Planning Application Ref: AW/161/21/T

Location: 219 Aldwick Road, Bognor Regis, PO21 3QG

Description of works: Reduce height of 2no. *Leylandii* trees to 6.5m

REF 1

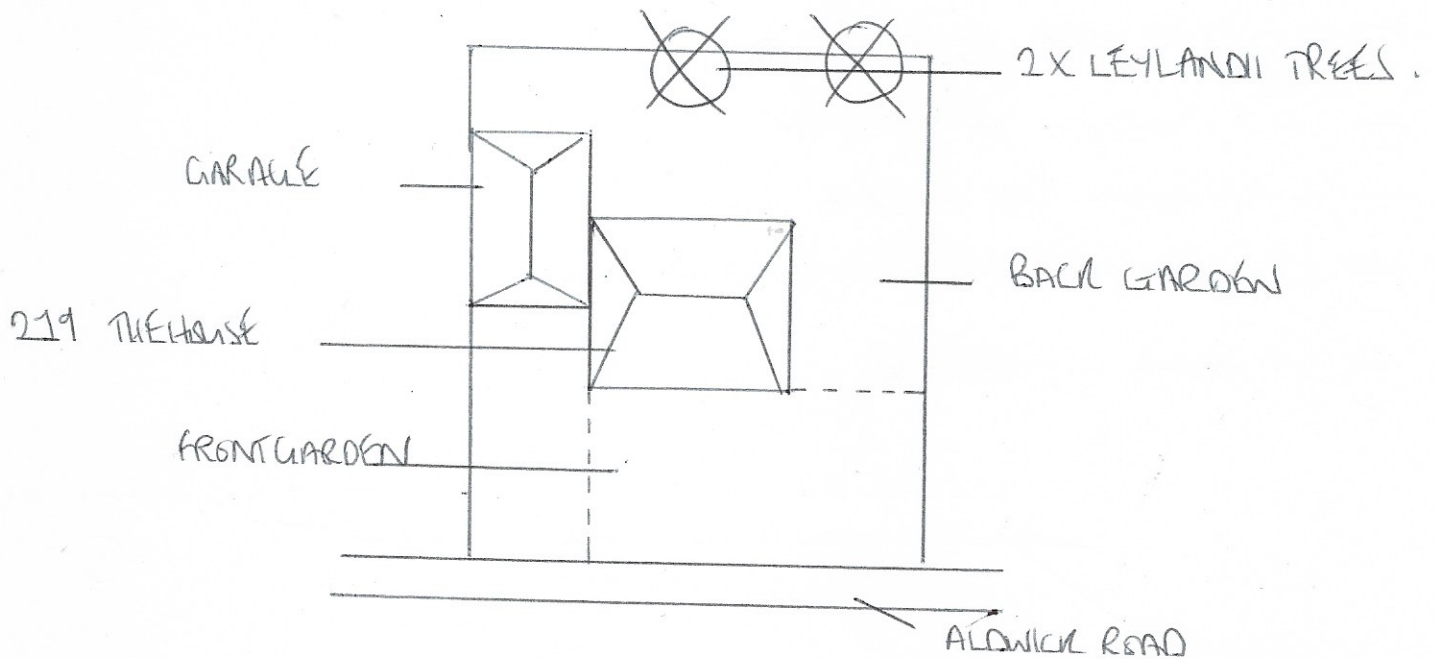
2x Monterey cypress/Cupressus macrocarpa Height: 5-10m, Radial spread: 0-5m, Age class: Late Mature

- Outwardly these trees appear to be in a fine physiological state despite their advanced years. They are large trees for their type although their crowns have been subject to hard pruning in recent years and visually unimpressive. They spread wide across the boundary from which they grow hard against.
- They are clearly visible from surrounding properties but only in part from publicly accessible land.
- It is stated on the application form (sect.7) “2 trees cut 2.5m off tops and sides”. This is clearly a proposal for whole crown reduction (intended or otherwise), i.e. to apply to both height and lateral spread on all aspects. Whilst this differs from the above Description of works, I am assured from my site meeting with the applicant that their intention is to also remove lateral growth and I submit my report on that basis.

- These trees require careful management that respects their age and vulnerability to environmental changes and disease progression. If the work is undertaken to a good standard and at the right time; then it is unlikely to have an adverse effect on their long-term vitality and visual amenity.
- The proposal to reduce crown height and spread to maintain reasonable use of garden space is justified and consistent with previous works approved by the Local Planning Authority.

- I recommend **CONSENT** for this application, subject to the following condition:

Part a) Where whole branches are to be removed and final cuts made close to the trunk or branch union they are to be made as shown in Figure 2 of BS3998:2010

Part b) Where branches are to be shortened back the final cuts are to be made at the correct angle shown in BS3998:2010 and adjacent to a live bud or lateral.
